# CITY OF ALBUQUERQUE

**Re: ARCHERY SHOPPE**  
**2900 Carlisle Blvd. NE**  
**Approval of Permanent Certificate of Occupancy (C.O.)**  
**Engineer's Stamp dated 05/25/2004 (H-17/D104)**  
**Certification dated 12/02/2005**

**Re: Archery Shoppe, 2900 Carlisle Blvd NE, Traffic Circulation Layout  
Engineer's Stamp dated 5-25-04 (H17-D104)**

T.C.L. PLAN

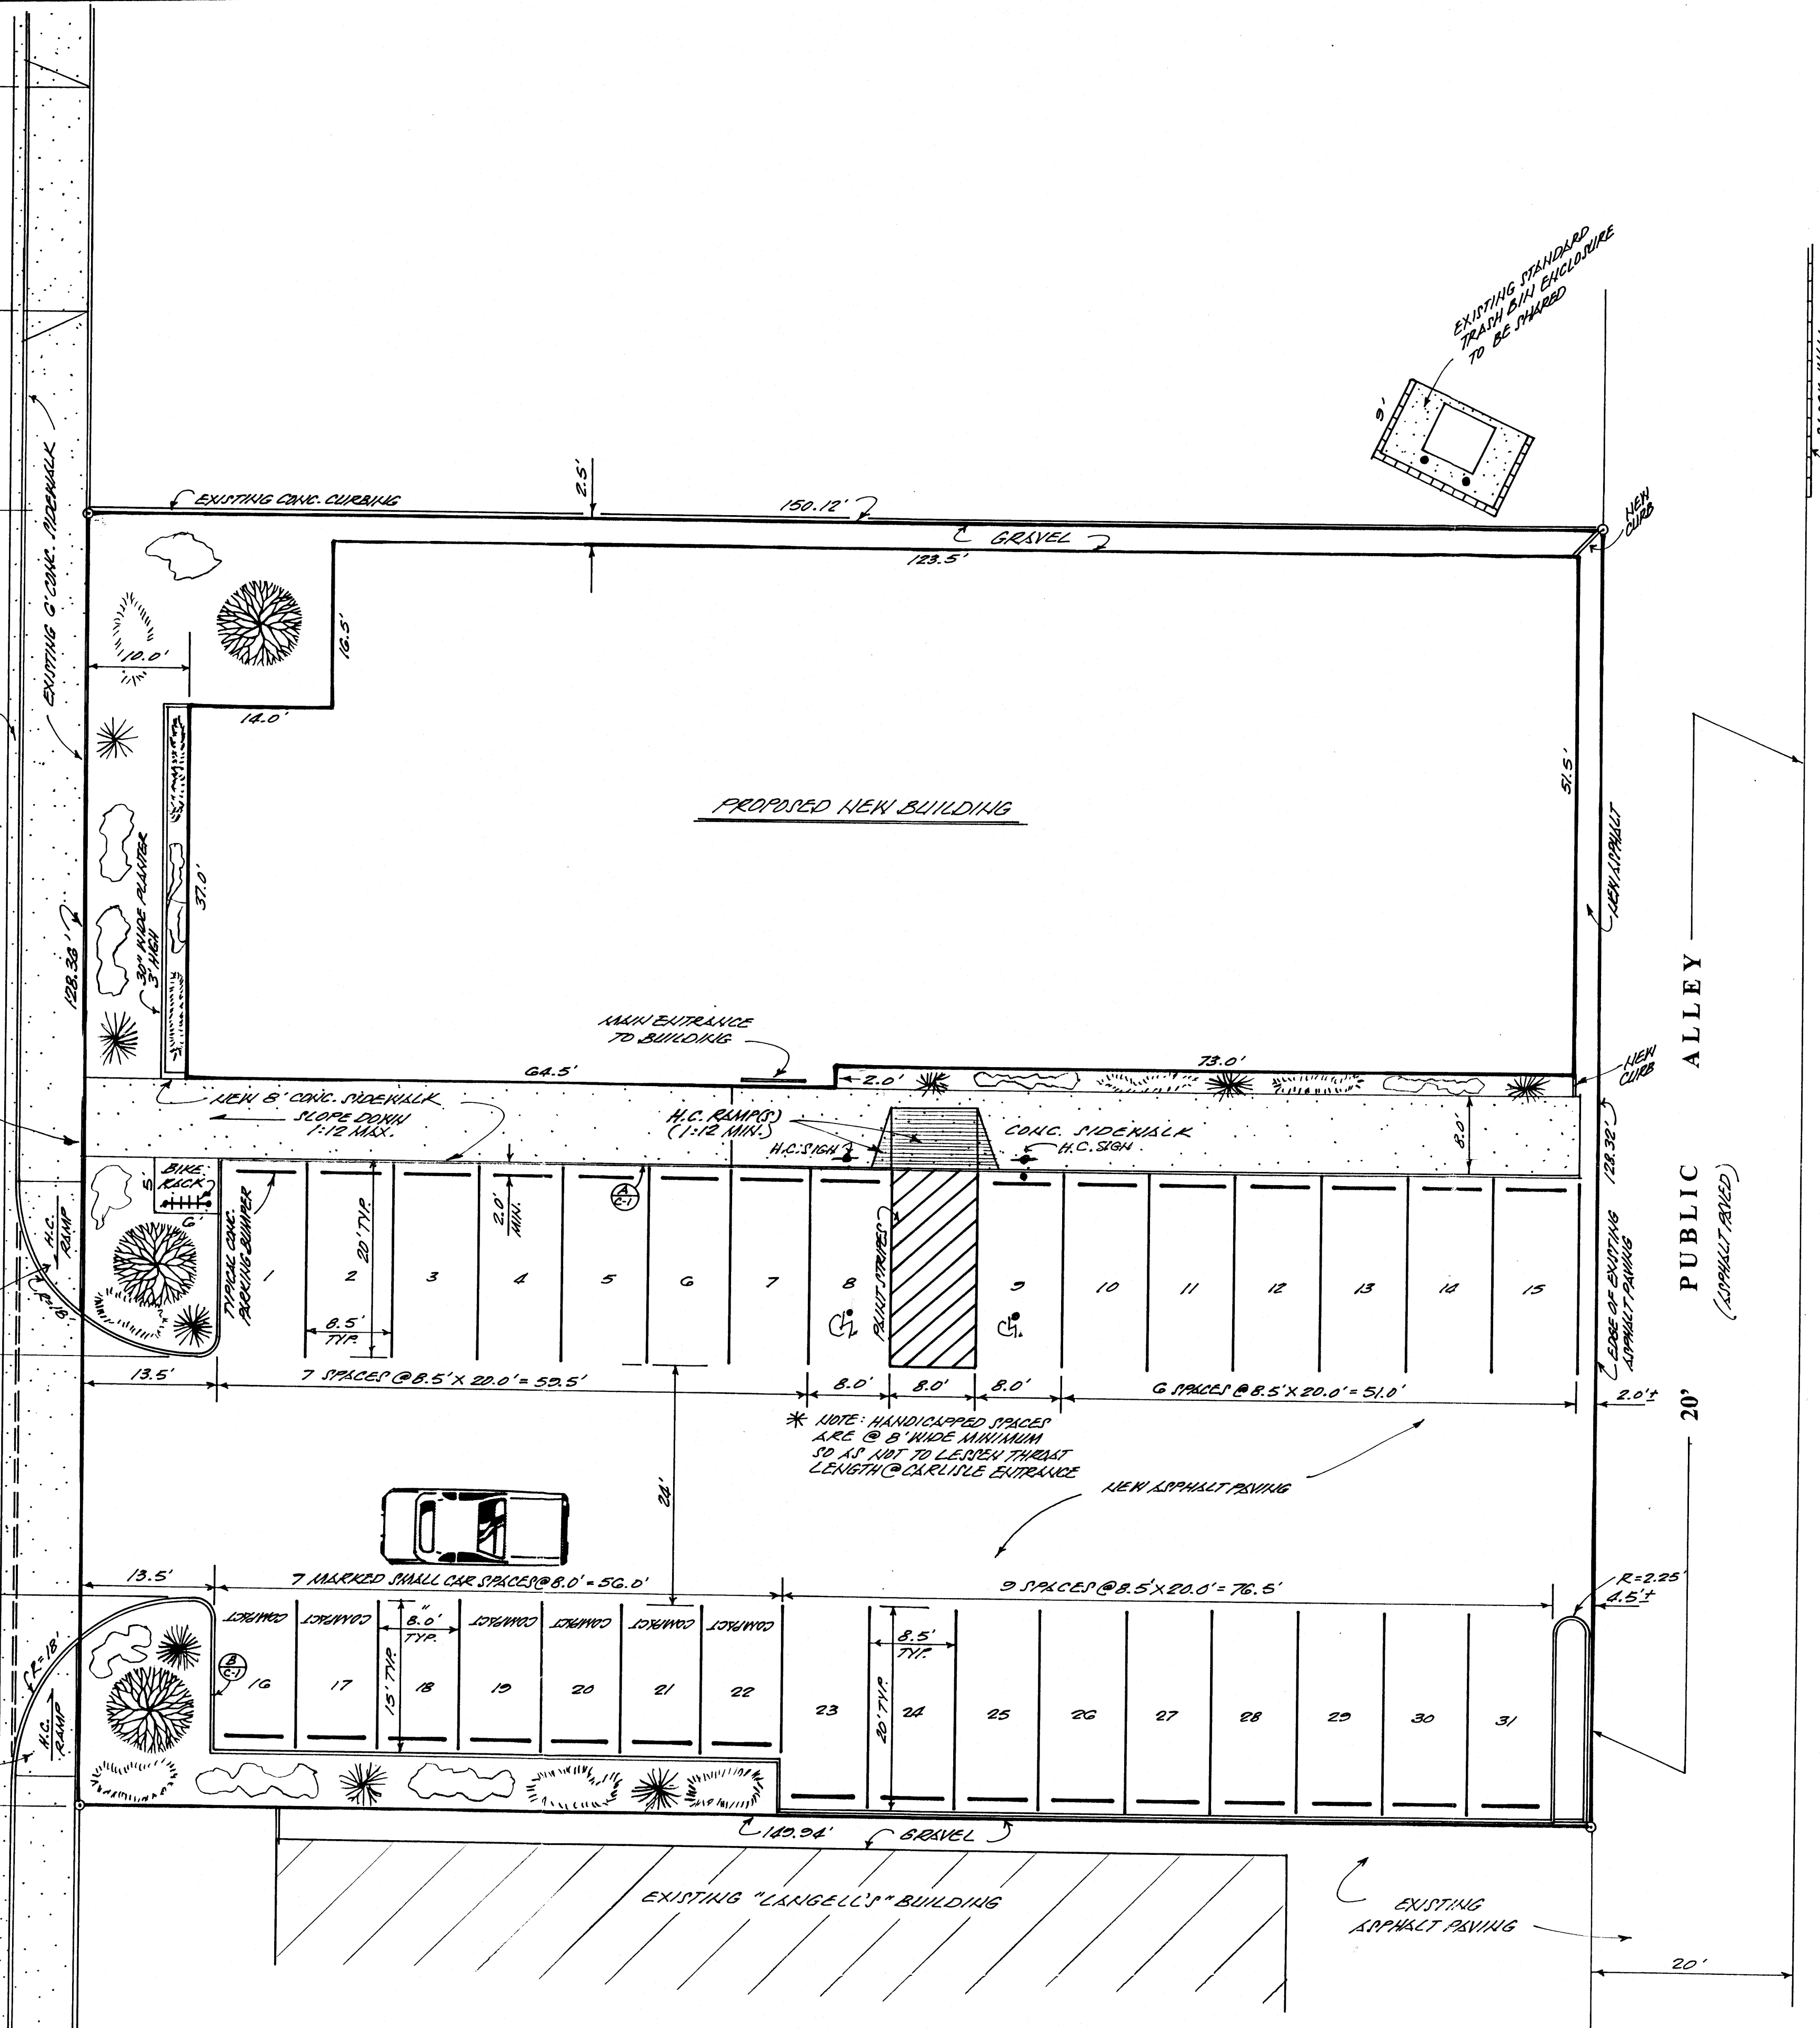
1. Please include 2 copies of the traffic circulation layout at the next submittal.
2. Refer to the appropriate city standard for the proposed driveway.

3. Label the compact parking spaces by placing the words "compact" on the pavement of each space.
4. Where is the building entrance?
5. Provide a copy of Solid Waste's response regarding the shared bin.

6. The proposed wheelchair ramp near the proposed building will not work; try using a level landing ramp.
7. Please show the location of the nearest driveway on the adjacent lot.

8. Separate the traffic circulation layout from the grading and drainage plan.
9. How does the 8 foot proposed sidewalk connect to the existing sidewalk along Carlisle Blvd?

10. Typically, the throat length for entrances along Carlisle Blvd. (a minor arterial) has a minimum length of 50 feet. Please determine how this would affect parking, and contact me to discuss this.

11. List the number of parking spaces required by the zoning code as well as the proposed number of parking spaces.
12. Is there a median break at the site?

13. Show a detail of the wheelchair ramps located at the proposed driveway, or refer to the appropriate city standard.
14. The handicapped spaces must be a minimum of 8.5 feet in width.

Required;  
separate docs  
Ask WG  
Regarding

Waived  
by  
WG  
access  
to alley
